PLANNING CONSULTATION RESPONSE

Application No	<u>2026/0327</u>
Proposal	Installation of black metal archway
Address	Armed Services Walkway, Westgate, Barnsley
Date of Consultation Reply	29/05/26
Consultee	Highways Development Control

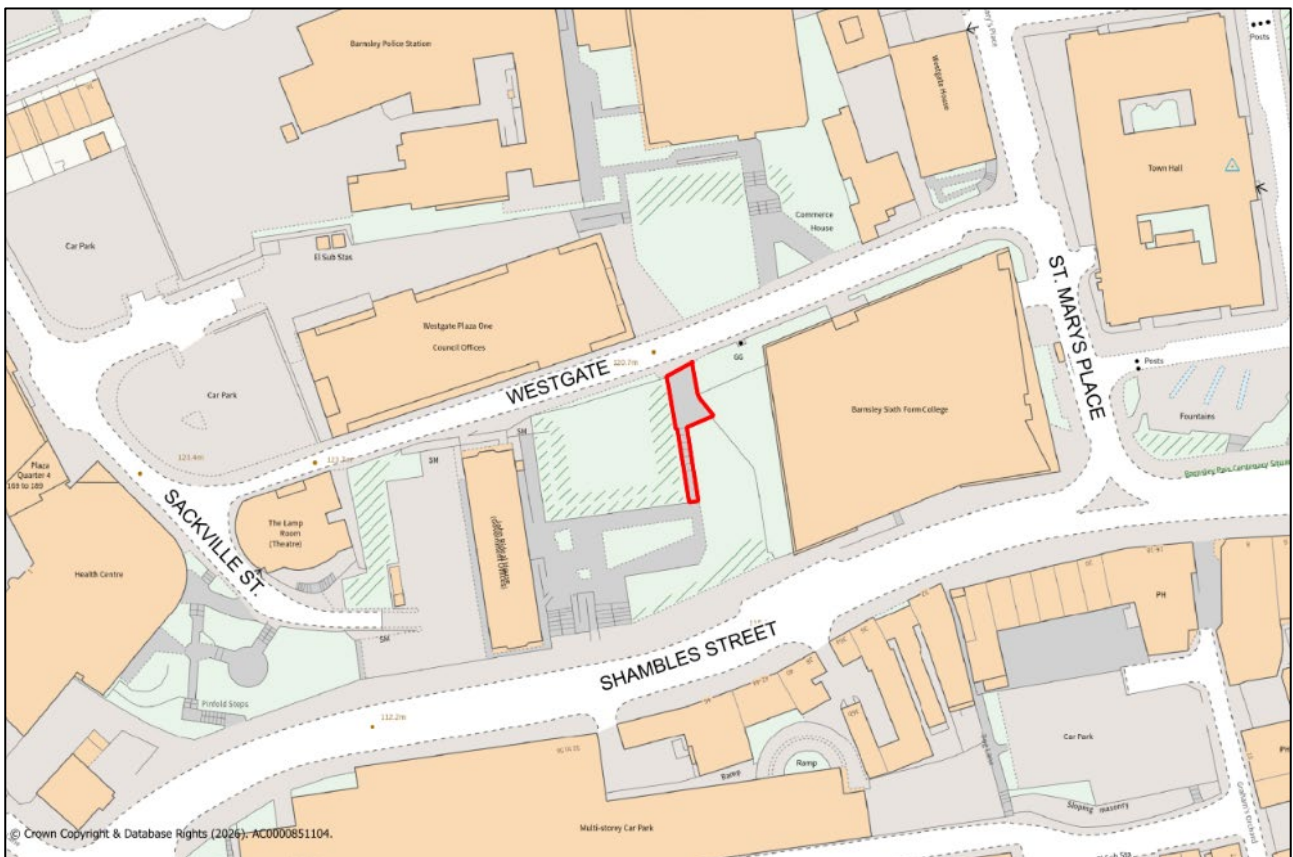
Whilst the route is not adopted highway, it is a registered Public Right of Way. Following internal consultation with our Structures Team, it is confirmed that the proposed archway would not be classified as a highway structure and therefore would not require Technical Approval, however, further information is required in respect of the proposed fixing and foundation details, which do not appear to have been provided as part of the current submission.
